Subject: Land at Bilsham Road - Y/155/20/DOC, discharge of condition 15

Simon J Davis MRTPI
Principal Planning Officer
Directorate of Place

BILSHAM ROAD, YAPTON			
Drawing Title: PRELIMINARY ENGINEERING LAYOUT. SHEET 2 OF 2			
Client: BILSHAM ROAD DEVELOPMENT LLP			
Scale: 1:500 @A0	Date: FEB 20	Designed: NA	
Drawn: LS	Checked: JH	Approved: GG	
Job No: 19-326	Drawing No: 19-326/010	Rev: J

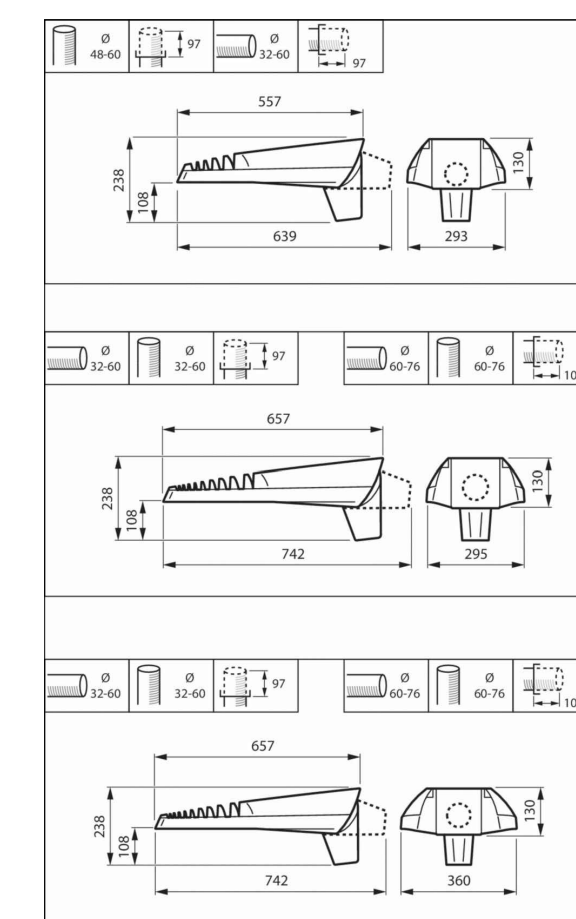
Regarding condition 15, both our Environmental Health Officer and our Ecologist comment that there is no lighting scheme for them to consider. In particular, our ecologist states that:

"Please can further information relating to the lighting scheme onsite be submitted with this application, including the details of the chosen light fittings for both external site lighting but also the external lighting on each property along with their locations. The information provided on the preliminary engineering layout is not sufficient. The application should be aware that the lighting will need to ensure there is no light spill towards any roofs, hedgerows and trees as this would disturb any foraging or roosting bats."
